From: Anita Gardner
Sent: 07 November 2017 11:20
To: Karen Parsons
Subject: FW: A/171/17/DOC - Discharge of Landscaping condition 10

Subject : A/171/17/DOC - Discharge of Landscaping condition 10

Proposed Cottages & Stables
 Herons Farm, Dappers Lane,
 Angmering
 Scale 1:200
 Drng no 459/08

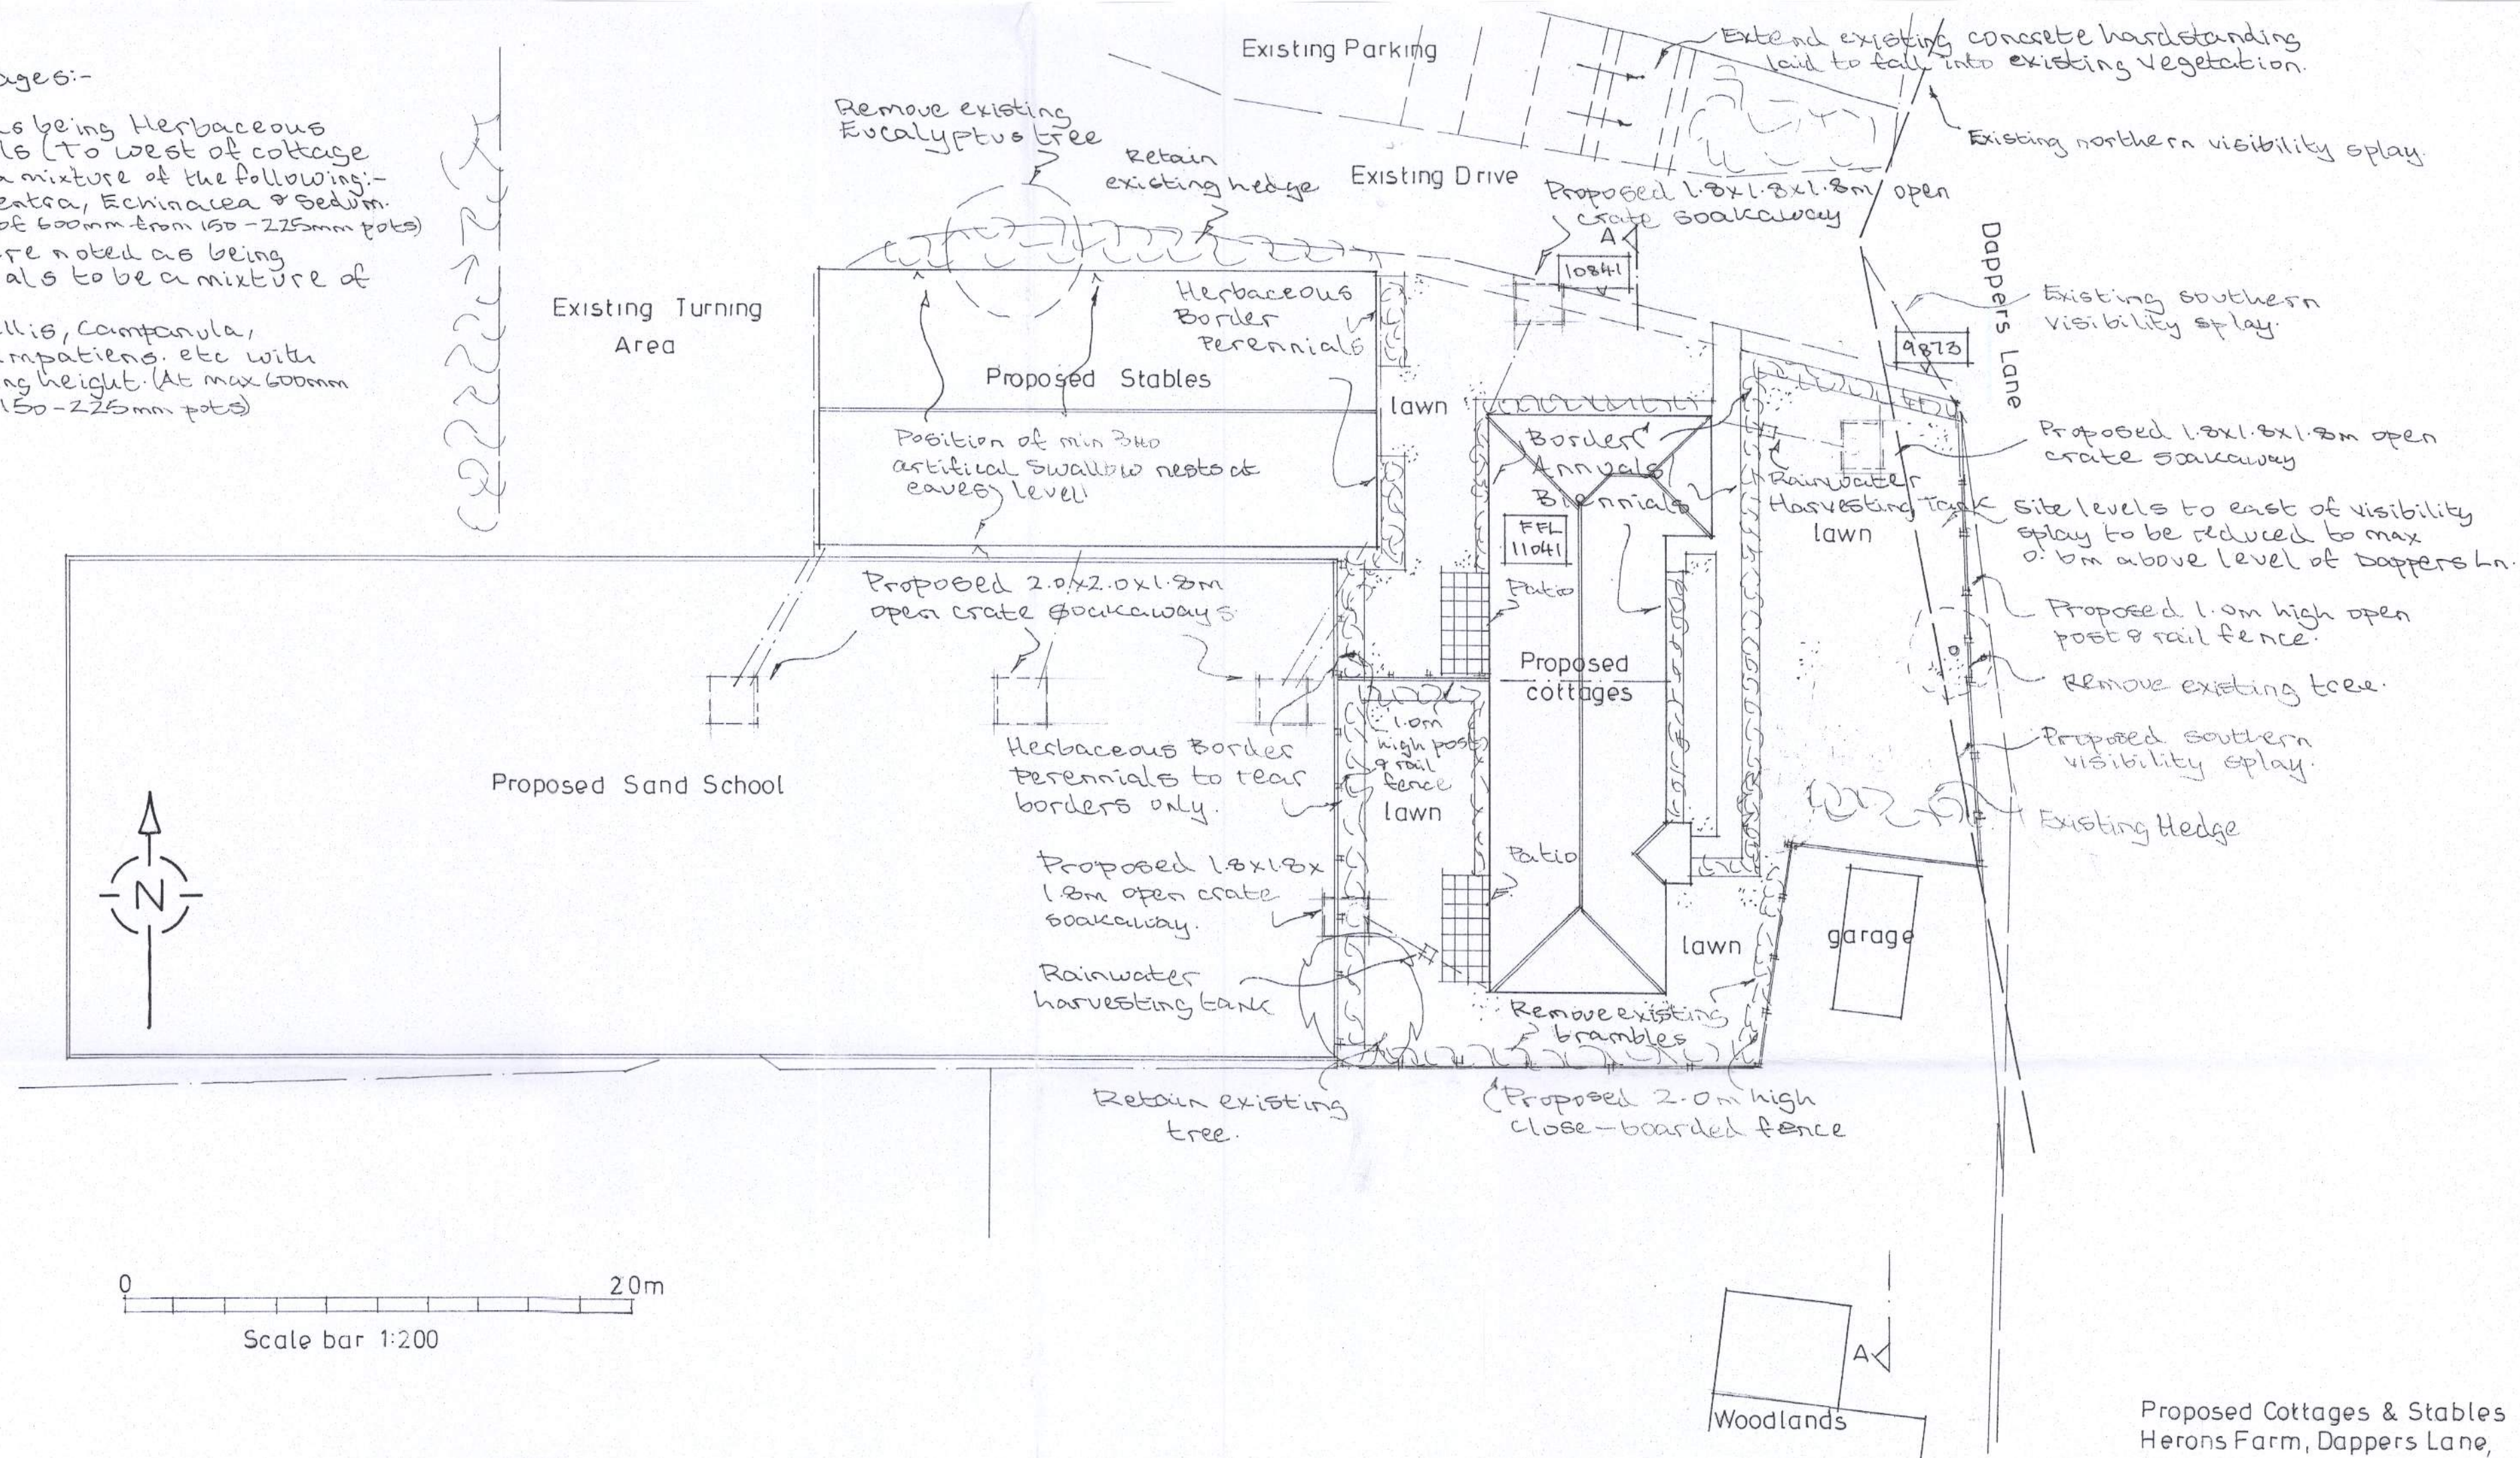
Dear Mr Andrews,
I am still awaiting receipt of the landscape officer's comments in relation to compliance with condition 10. I note that no plant numbers or plant or pot sizes are included with the application and this will be required before the condition can be considered further.
I would therefore be grateful for your agreement to a 2 week extension of time, until 16-11-2017, to allow for receipt of further details and the landscape officer's comments
Regards
Anita Gardner
